**KIRKLEES METROPOLITAN COUNCIL
INVESTMENT & REGENERATION SERVICE**

DELEGATED DECISION TO DETERMINE PLANNING APPLICATIONS

Reference No:	2024/62/90738/W
Site Address:	1, Butterley Lane, New Mill, Holmfirth, HD9 7EZ
Description:	Erection of first floor rear extension and alterations
Recommending Officer:	Laura Yeadon

DECISION – REFUSED

General Arrangement as Proposed

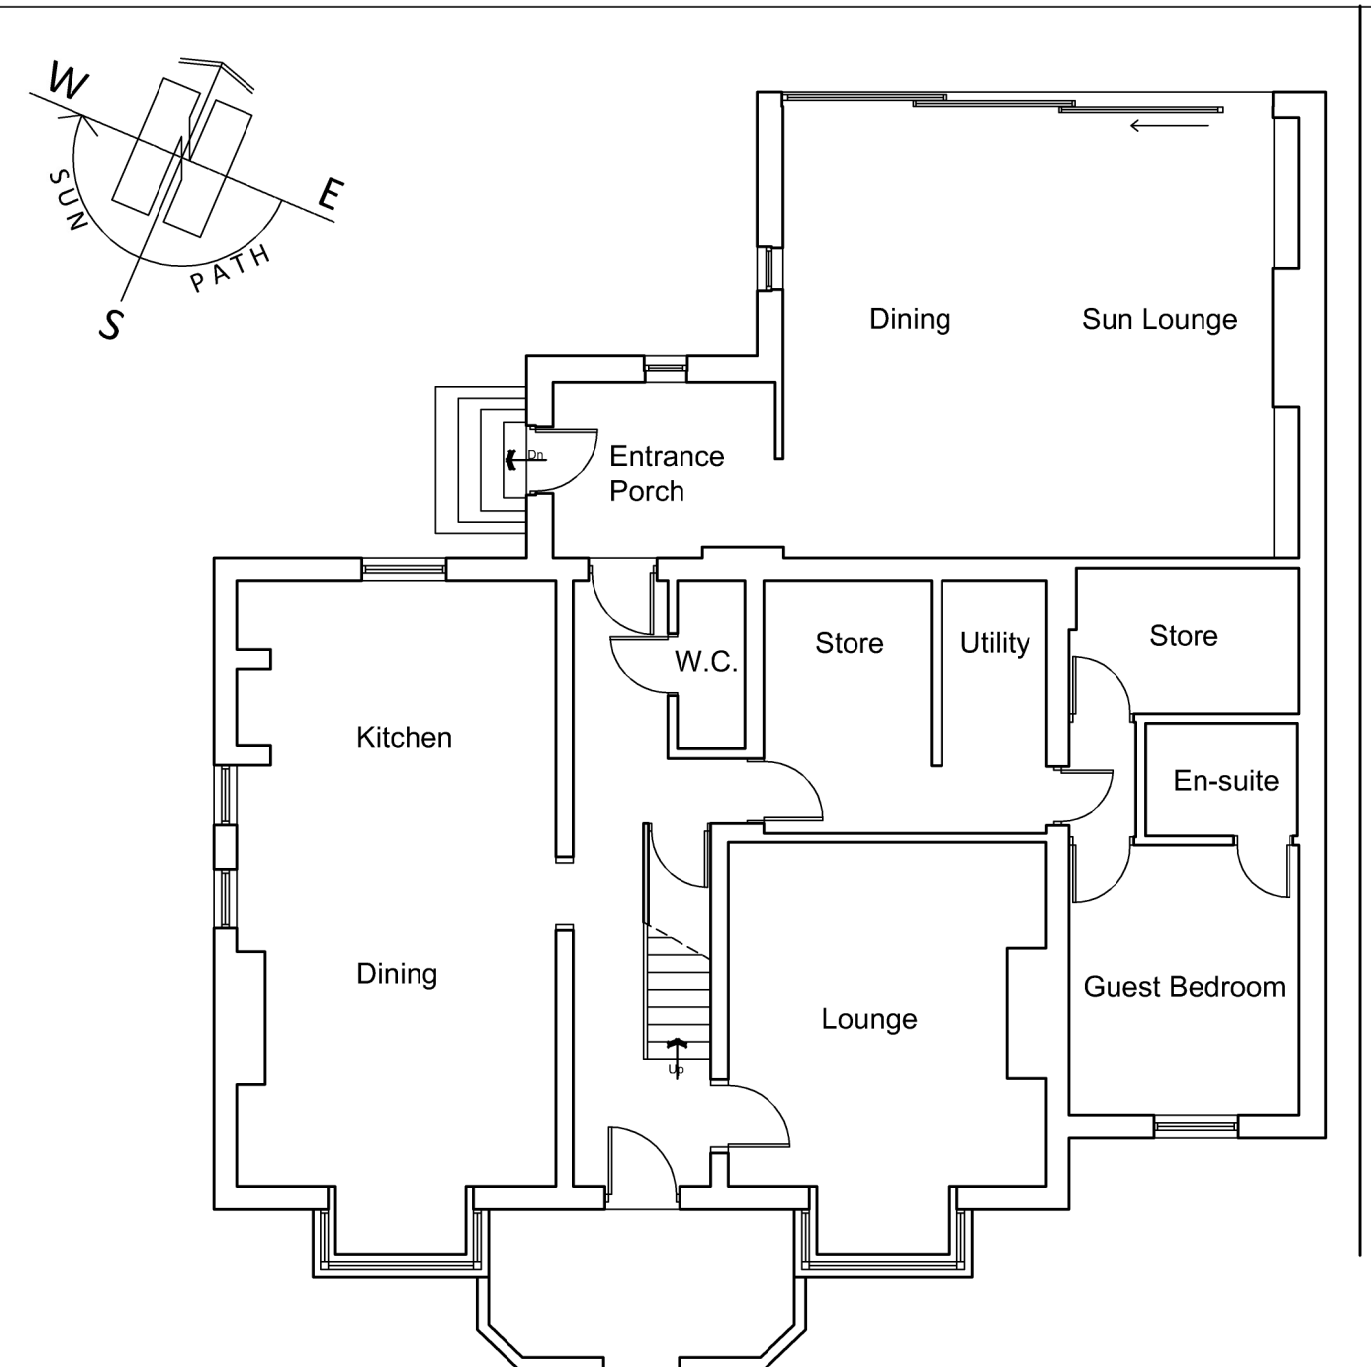
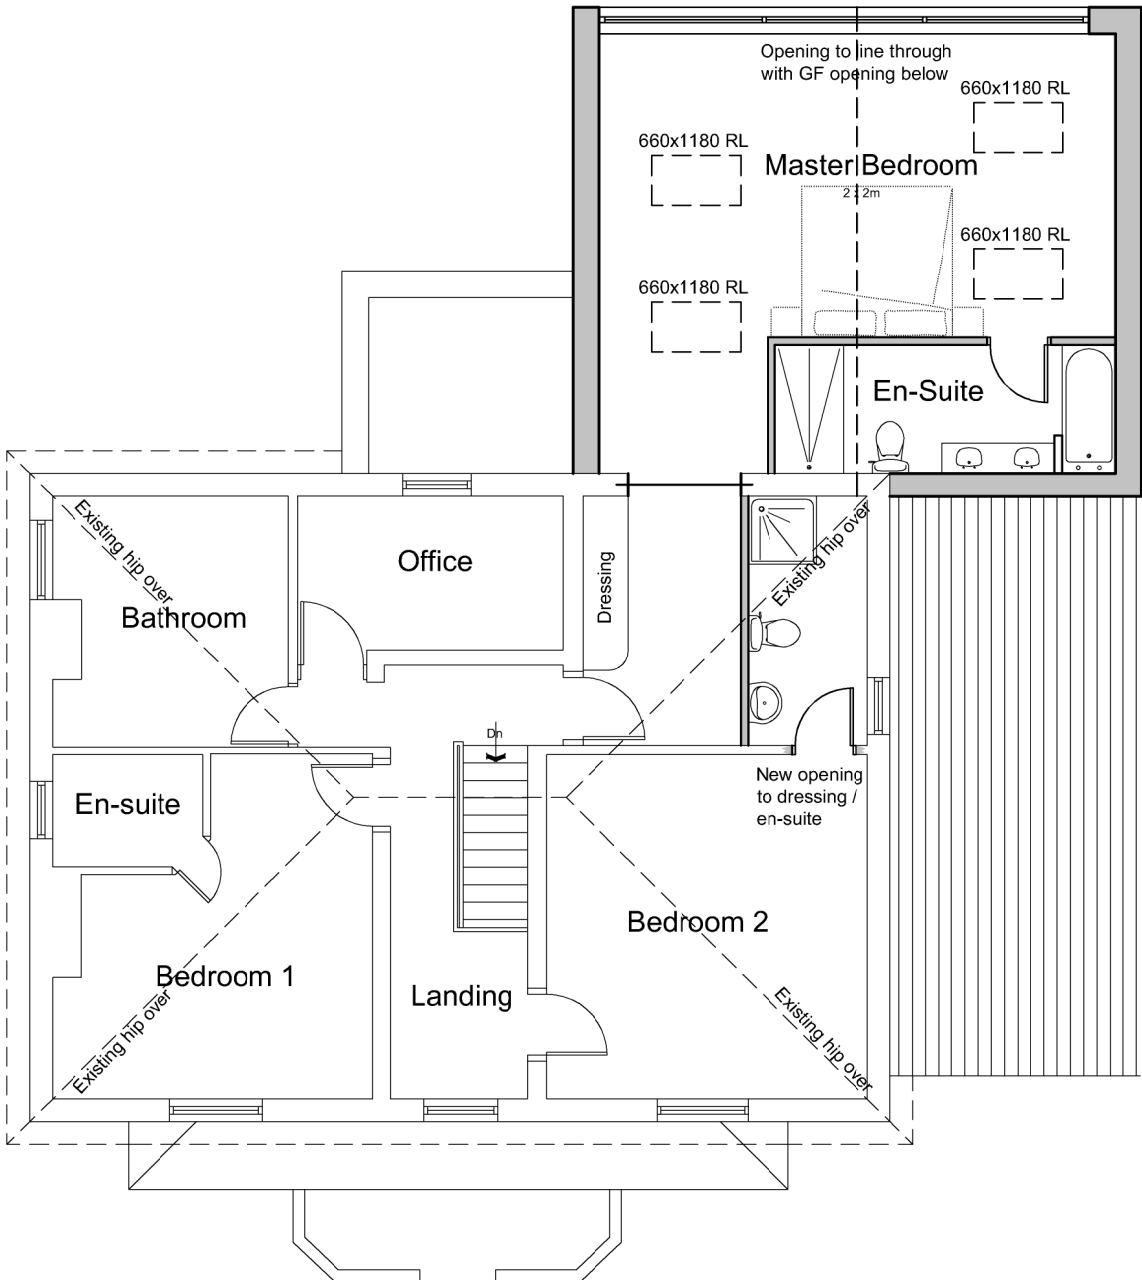
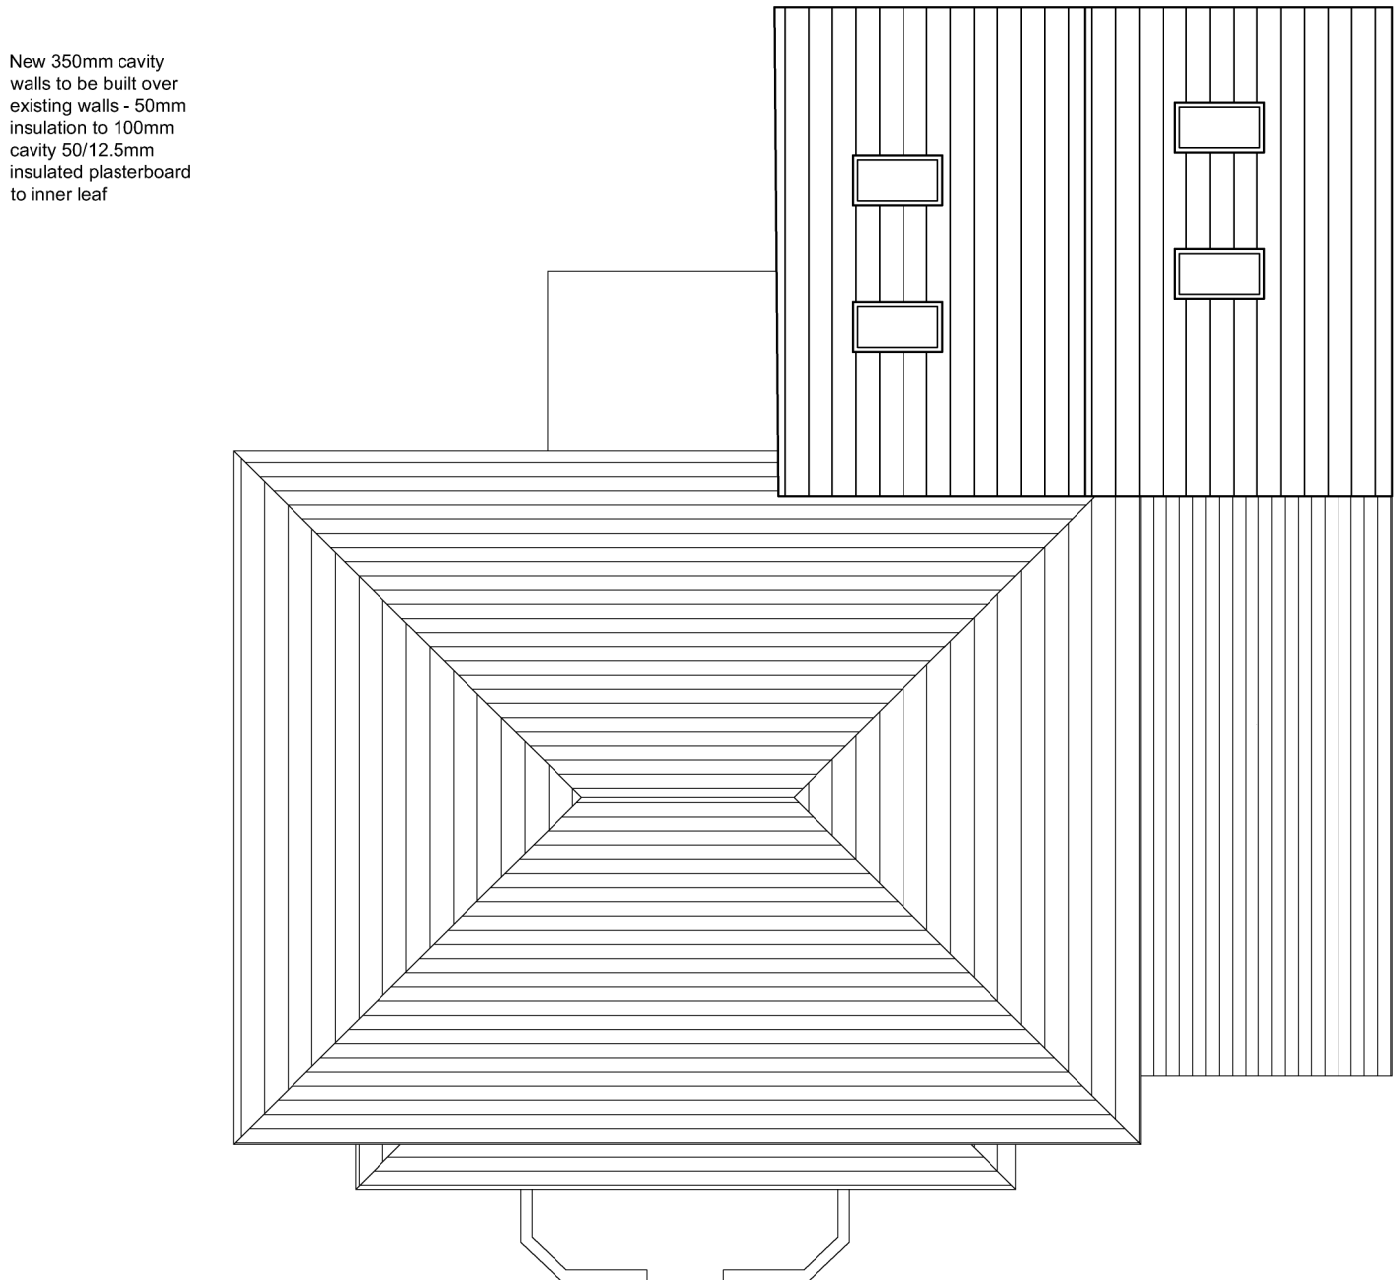
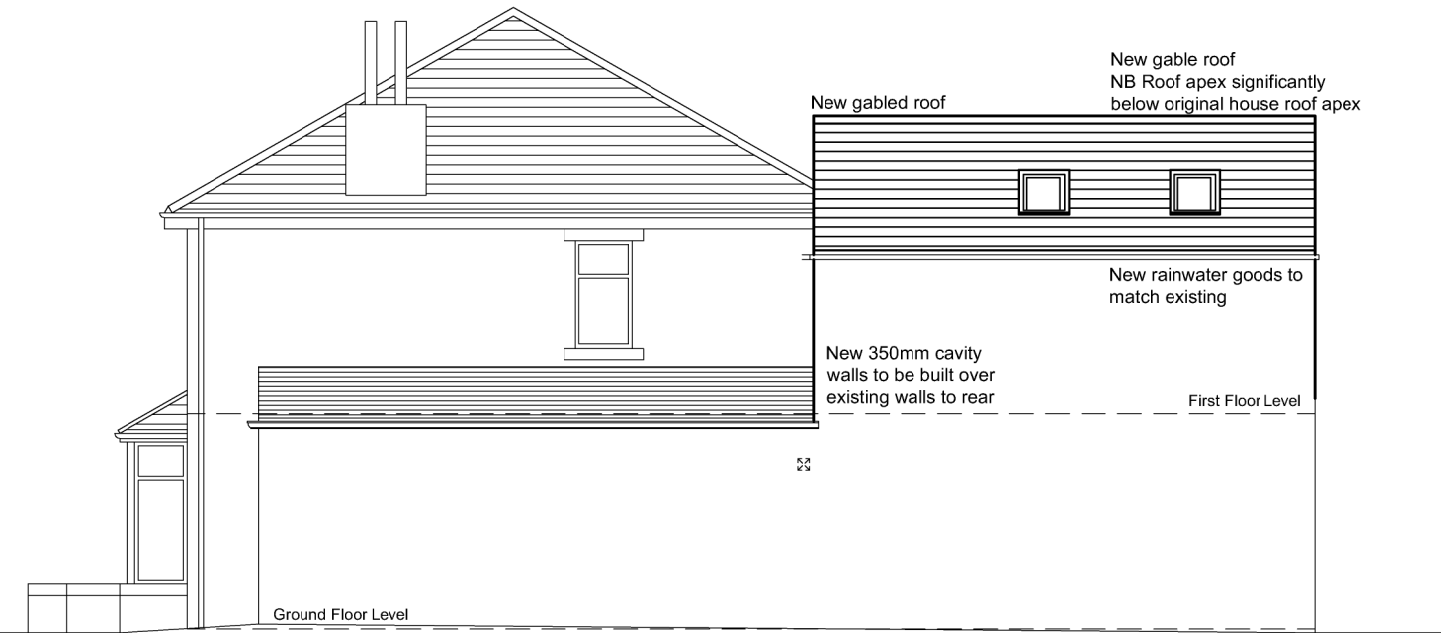
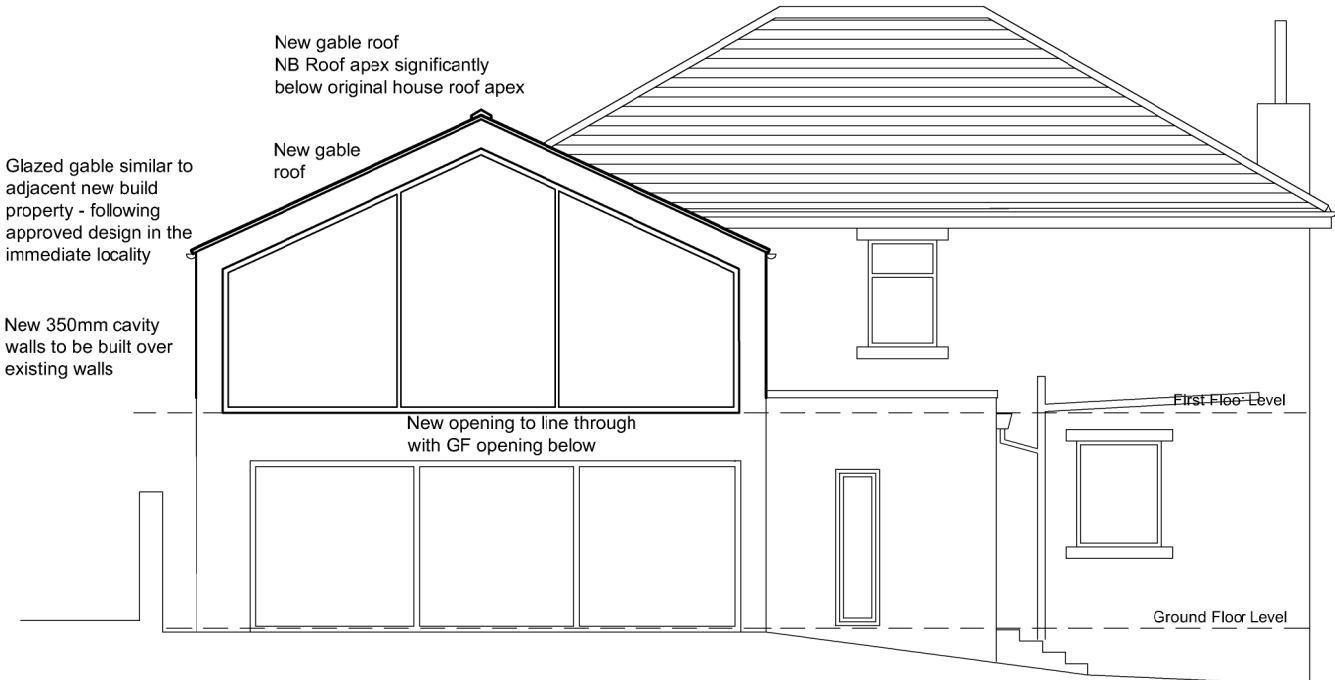
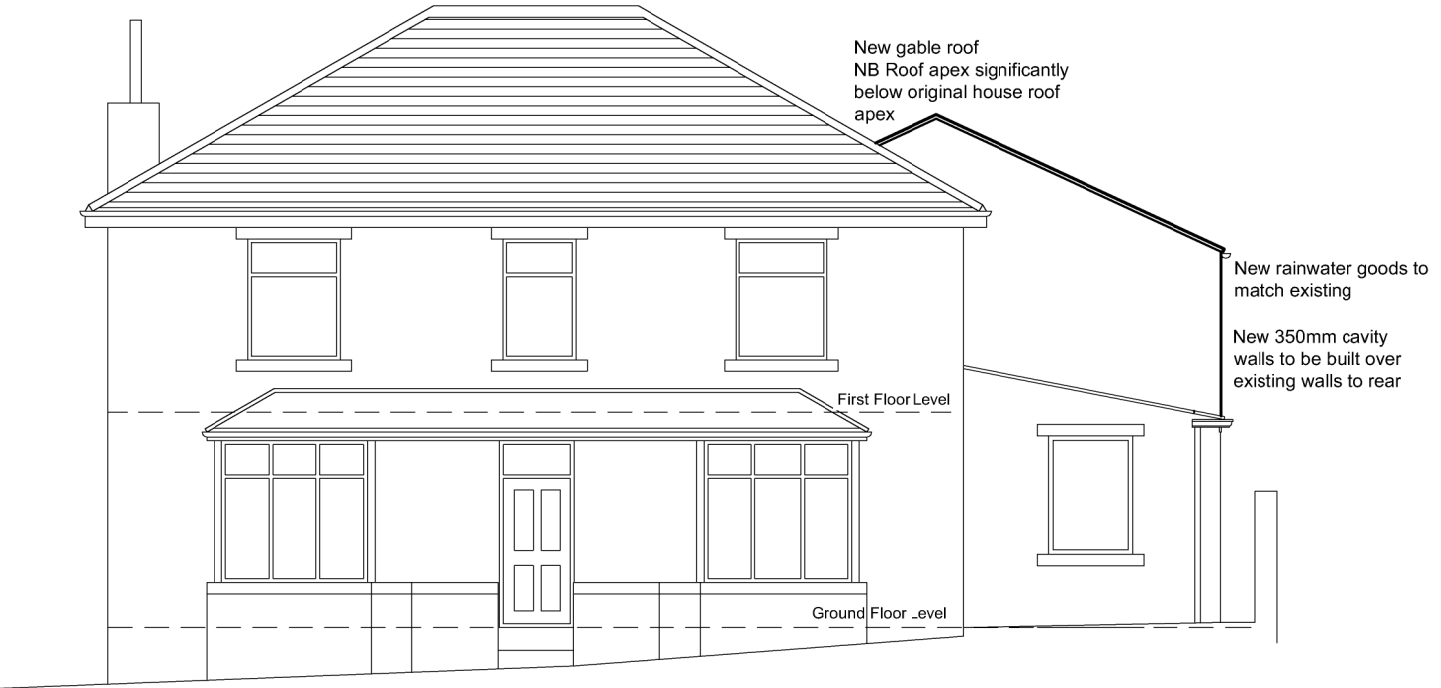
In this instance, the proposed extension would sit above the existing ground floor elevations, with the projection off-set from the original side elevation of the property and therefore, reference to the SPD and side extensions are a material consideration.

With specific regard to the resultant projecting side extension, this would take up all the space to the side of the property and would not maintain a 1 metre gap to the boundary. Notwithstanding this, the works would be above the rear section of the existing single storey element and due to the adjacent neighbouring property being set in from the boundary and being detached, a sense of space would be retained between the 2 no. dwellings.

In terms of the rear extension when assessed taking into account the ground floor extension, it is not considered that this would comply with sub-paragraph 5.8 of the SPD. The proposed main rear section of the extensions would not be proportionate to the size of the original property and whilst there would be sufficient garden space remaining, the proposed works far exceed the parameters of the SPD which states that extensions should not exceed more than 4 metres on detached properties. The extension itself would project 6 metres at two storey height which would not comply with the SPD and would be visually disproportionate, visually intrusive and out of character with the host and surrounding development.

As previously assessed it is not considered that the works, whilst being predominantly to the rear of the property, would be a subordinate addition and would present an undue level of bulk and massing to the side and rear of the property which appears overly dominant and out of keeping with the original property.

In terms of the adjacent property to the east, this is a small bungalow with the proposed extension creating a two storey structure along the boundary of the site which would project from a similar rear elevation building line to the bungalow. Whilst there are no proposed openings within the side elevation of the extension which would give rise to overlooking at close quarters, due to the siting of the extension, along the shared boundary of the site the works would result in an oppressive feature which would tower above the amenity space to this property and would reduce the amount of natural light to the amenity space. This also formed a reason for refusal as part of the previous refusal.

The Planning Statement seeks to overcome this reason for refusal by demonstrating that the 45 degree line would not be cut between the mid-point of the rear elevation rather than the mid-point of an existing window within the rear elevation of the property and therefore, the 45 degree line would be cut in this instance and therefore would fail to comply with the SPD in this regard.
